DRB Application No.: <u>04DRB-00631 (P&F)</u>	Project # <u>1003277</u>
Project Name: <u>Desert Ridge Office Park</u>	
Agent: <u>Jeff Mortensen & Associates, Inc.</u>	Phone No.: <u>345-4250</u>

Project Name: **Desert Ridge Office Park**

CITY OF ALBUQUERQUE
PLANNING DEPARTMENT
DEVELOPMENT REVIEW BOARD

Project # 1003277

**CONCEPTUAL GRADING PLAN
DESERT RIDGE OFFICE PARK**

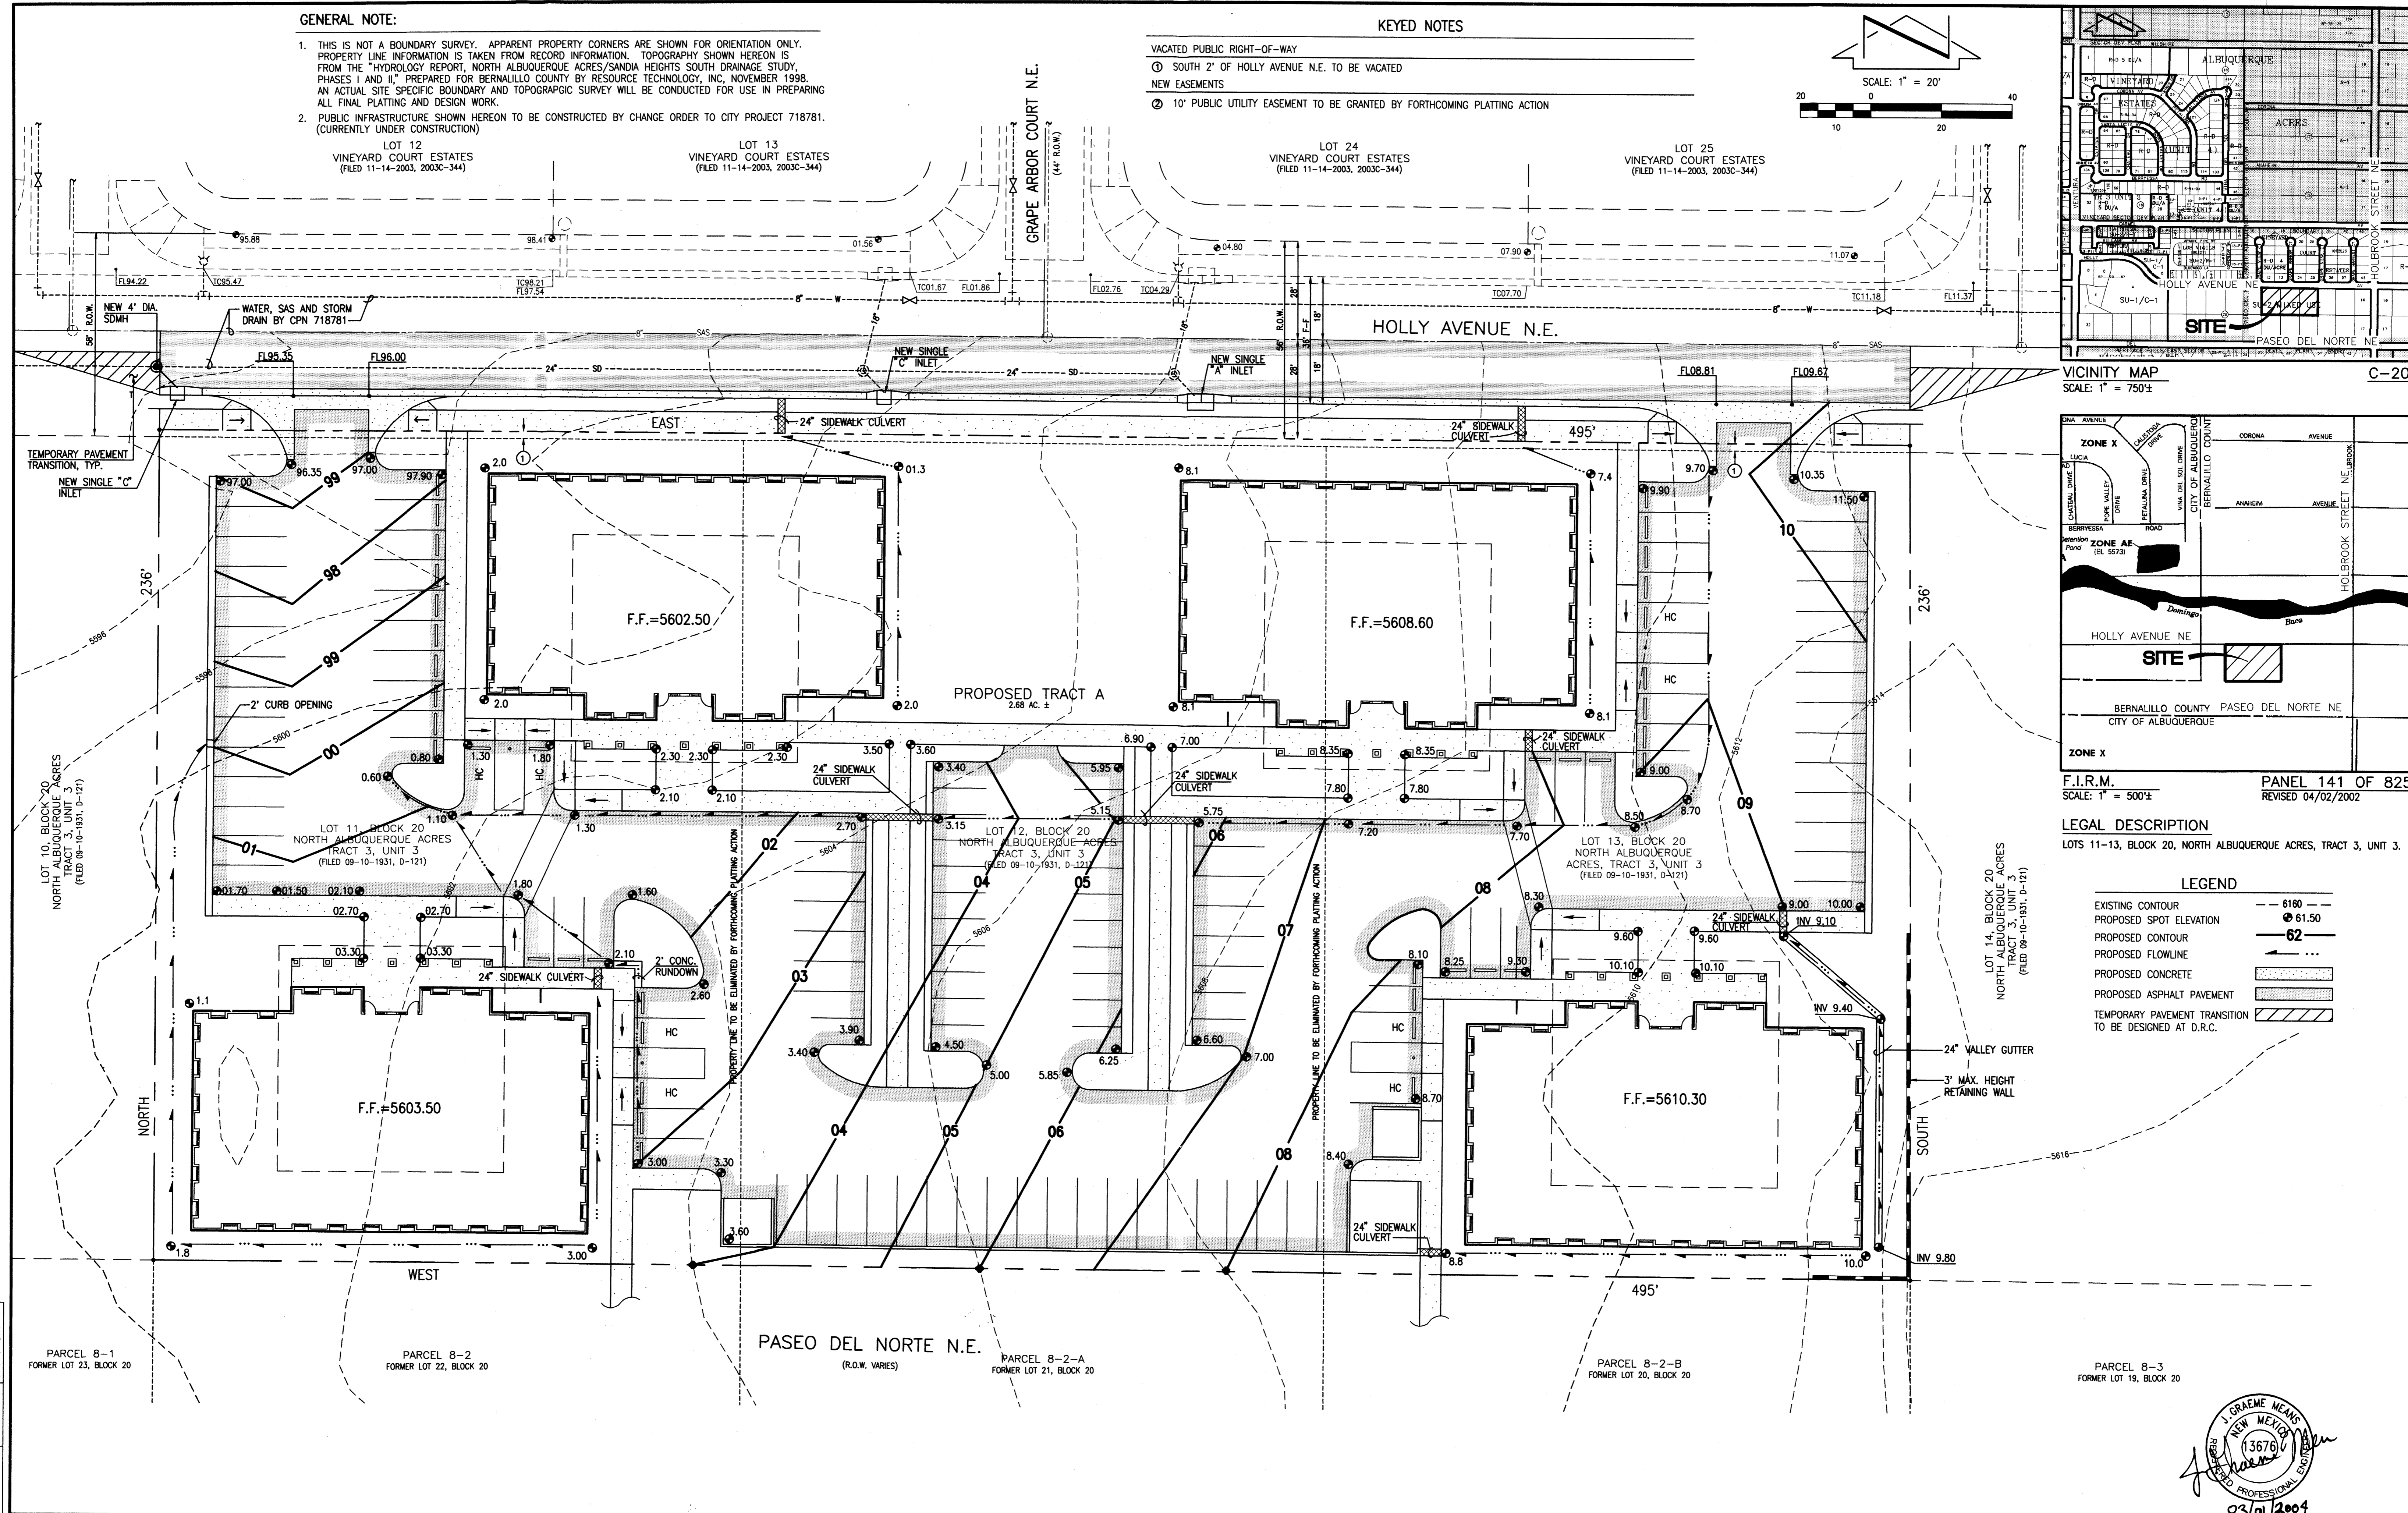
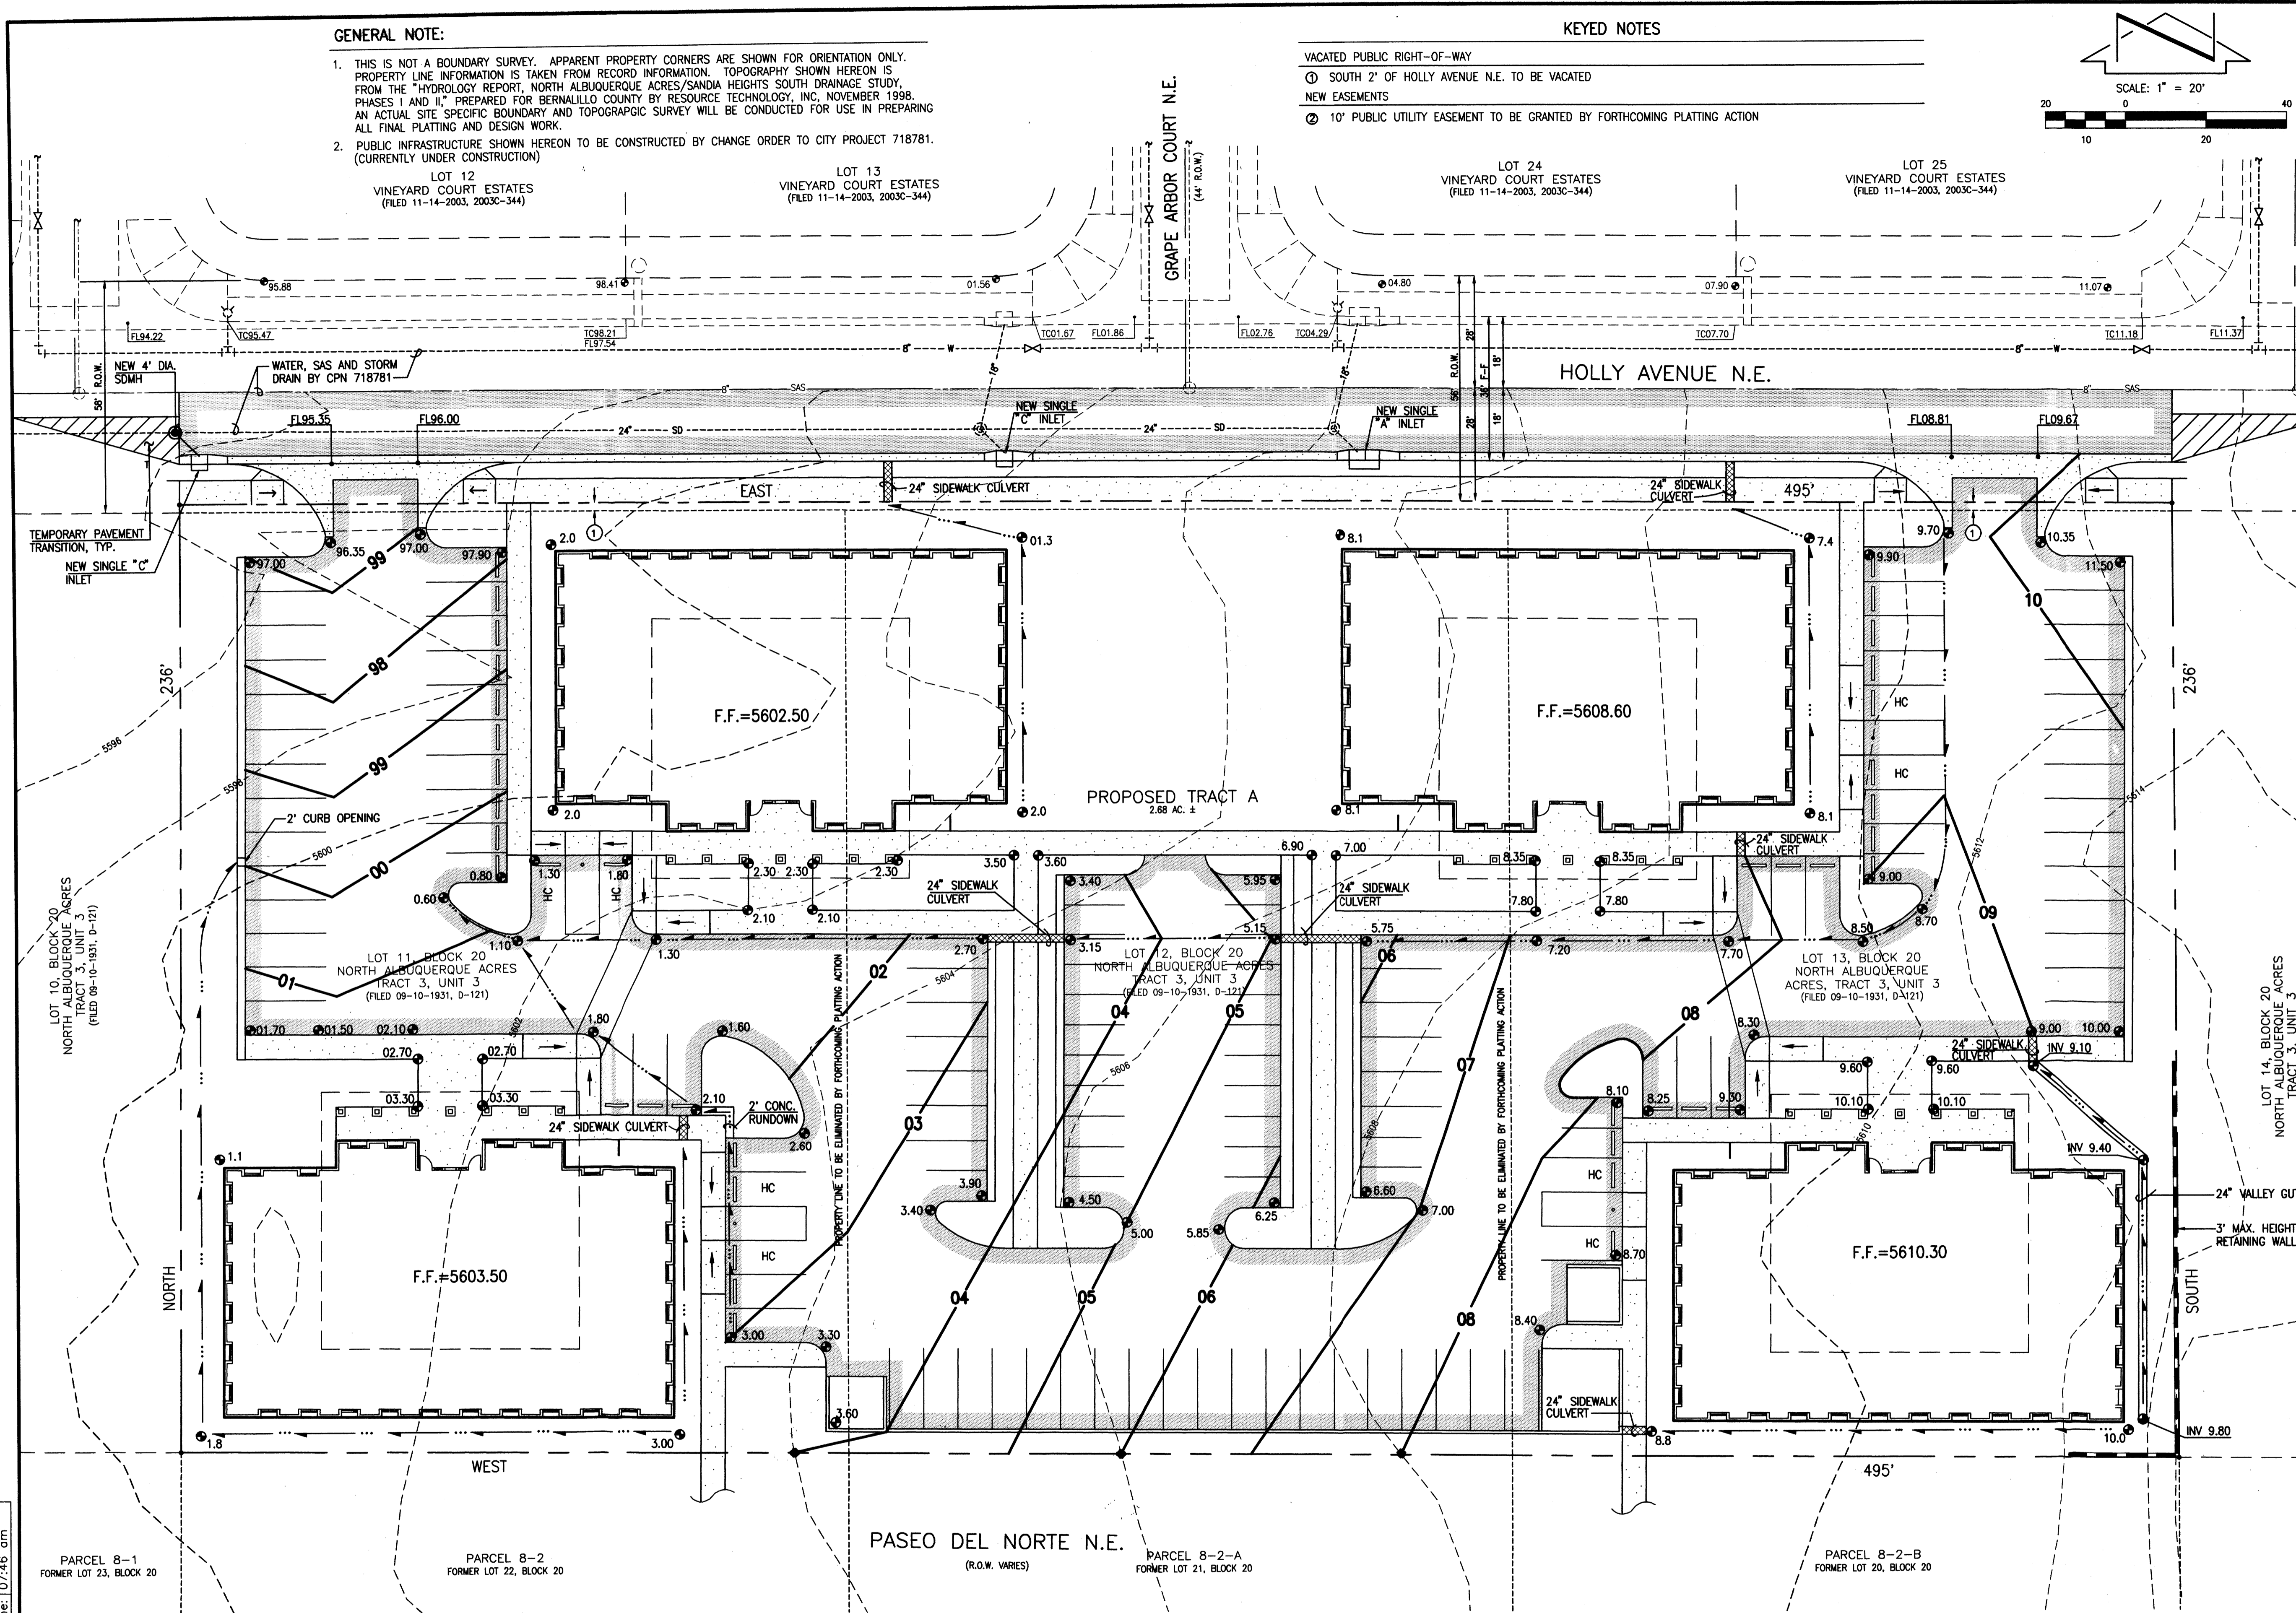
No objection to Vacation requests. No objection to Preliminary/Final Plat approval. No objection to Site Plan approval except that directional wye's are required to connect 6" sewer service lines to the 8" main.
